H09-0619-22 Comments - Land Off Fen Road Holbeach Spalding

Please find below response to The Trees and Nature Conservation Officer received 22nd July 2022

PROJECT:	Proposed Residential Development at Fen Road, Phase 2		
DRAWING:	Tree Protection Plan		
SCALE:	1:500@A1	DRAWN:	GP
DATE:	MAY.2022	REVISION:	B
DRAWING No:	127-TP-01

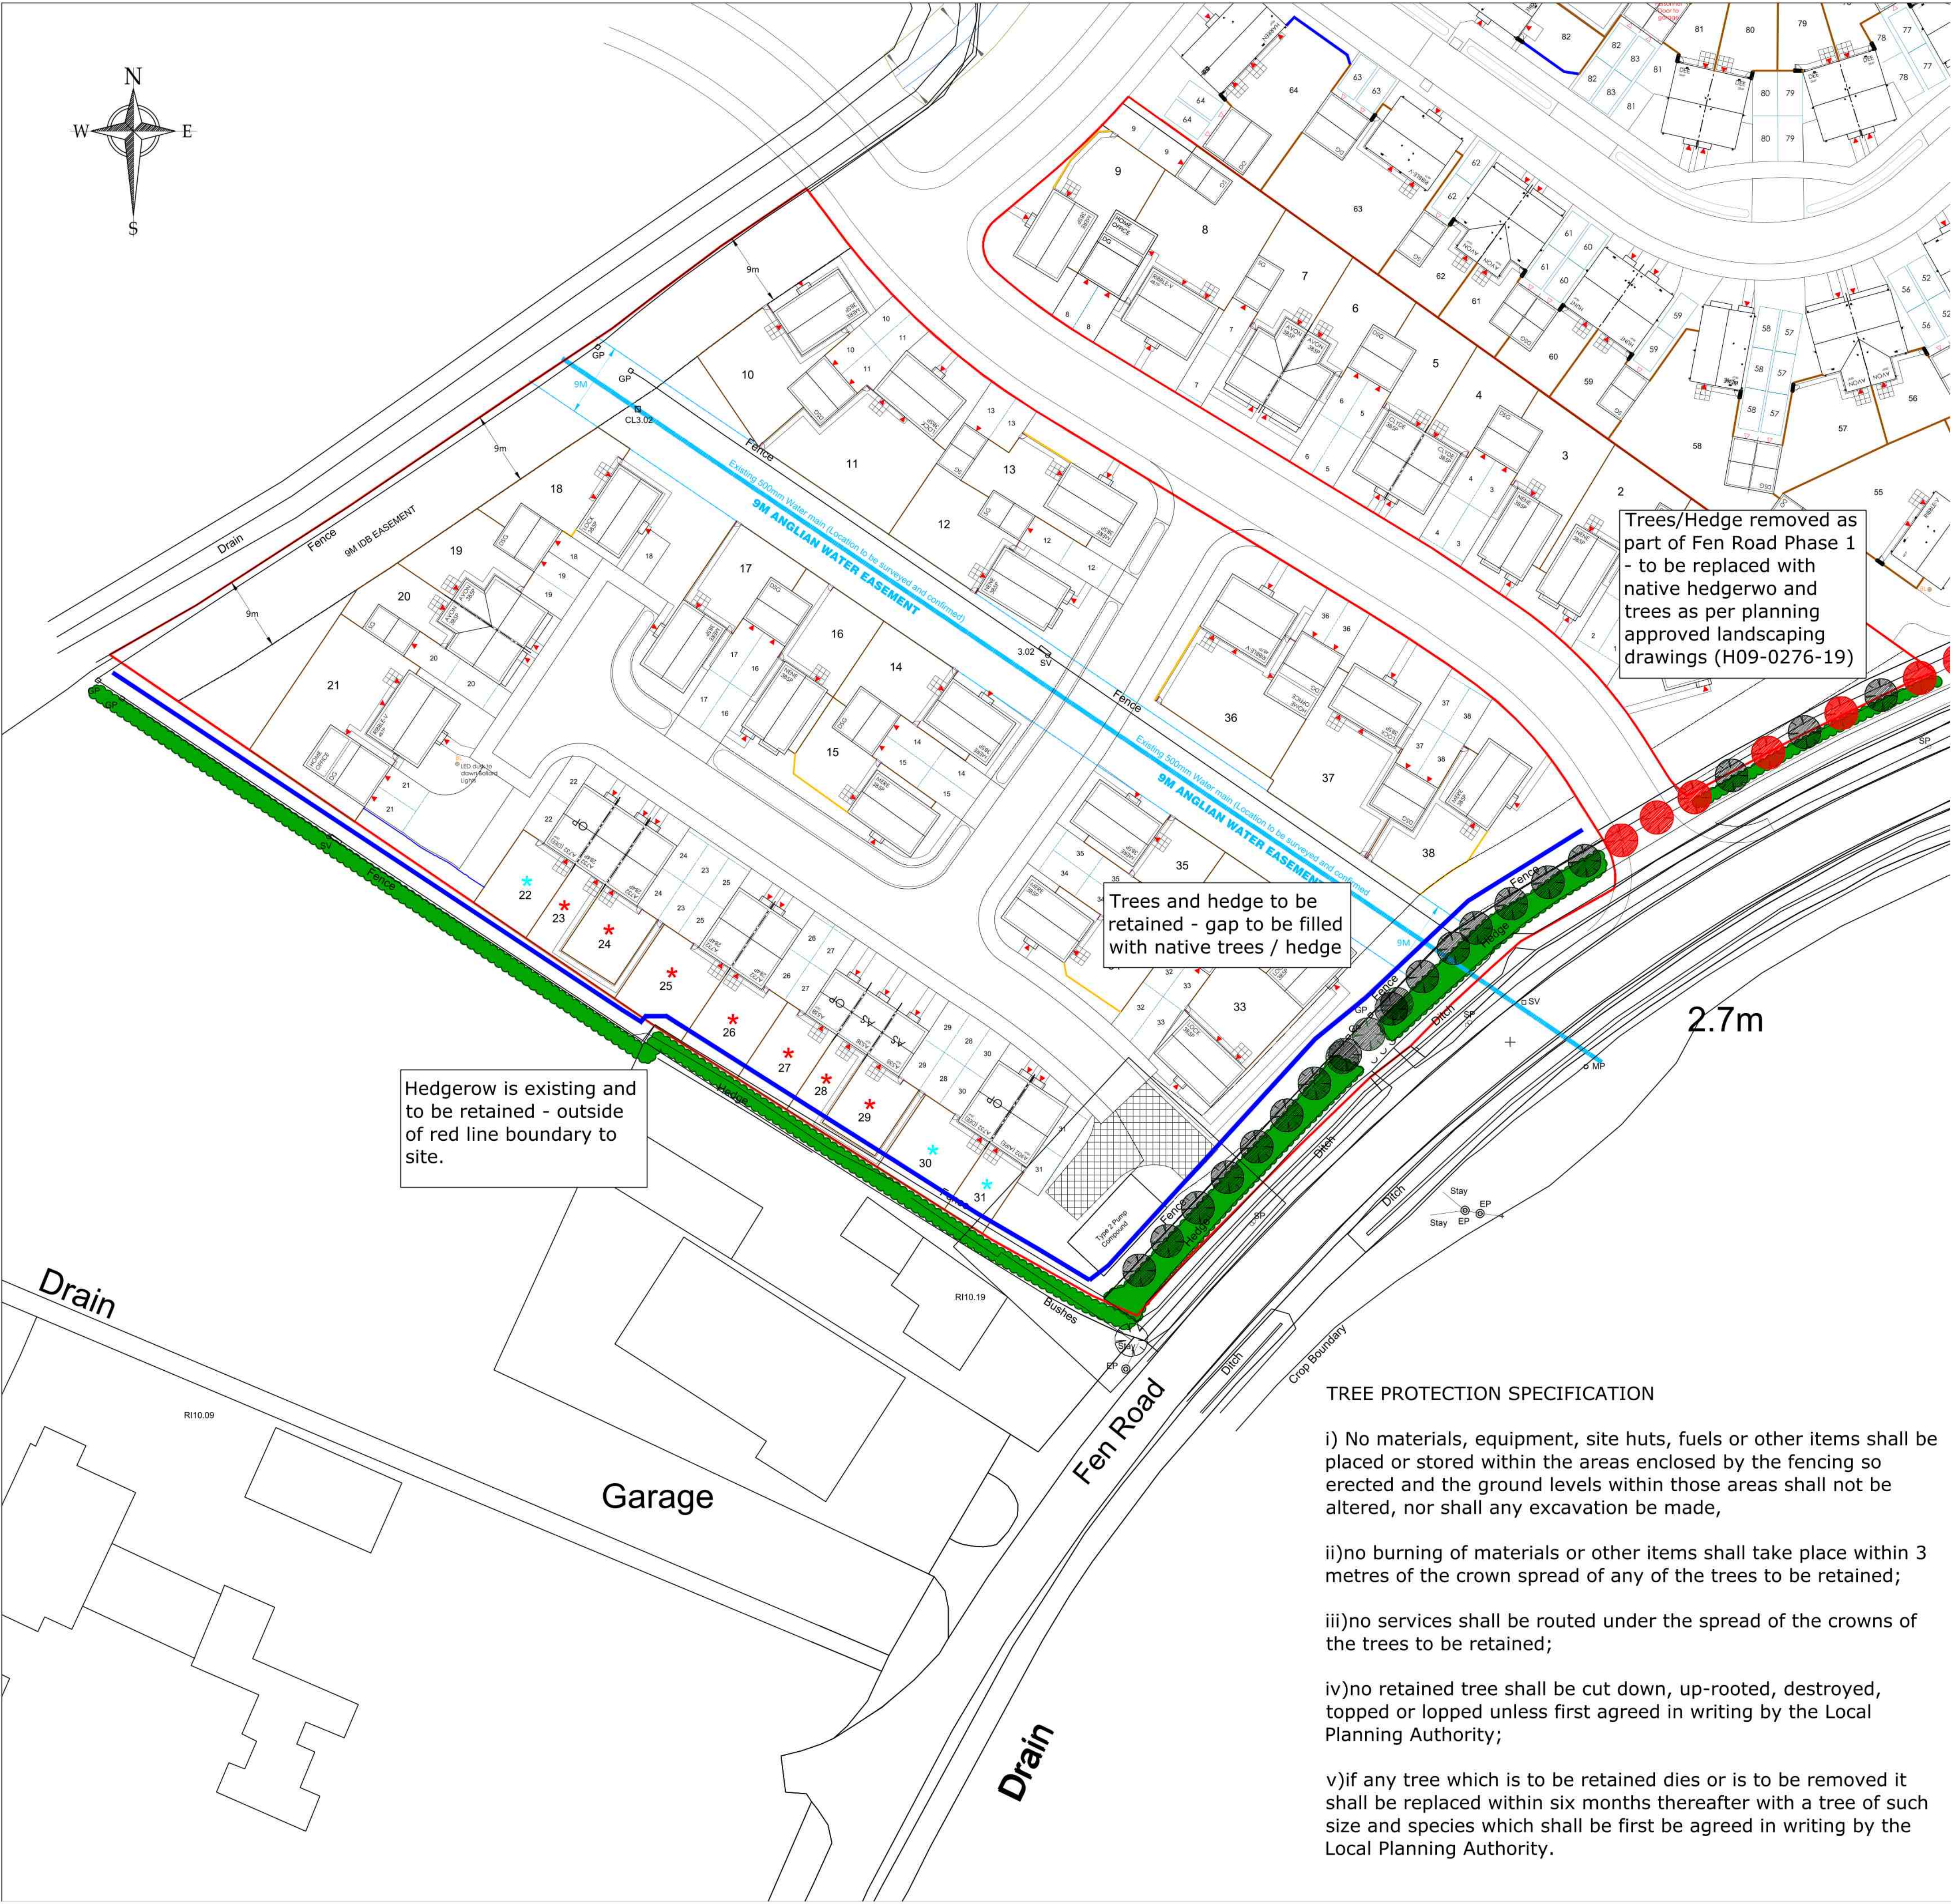
DRAWING 127 – TP - 01

We attach revision A of drawing 127-TP-01 which is now correctly titled Tree Protection Plan. This was erroneously titled Biodiversity Plan previously.

The drawing has been clarified with the key coloured to suit the plan, alongside text descriptions detailing the extent of trees / hedgerow being retained on site.
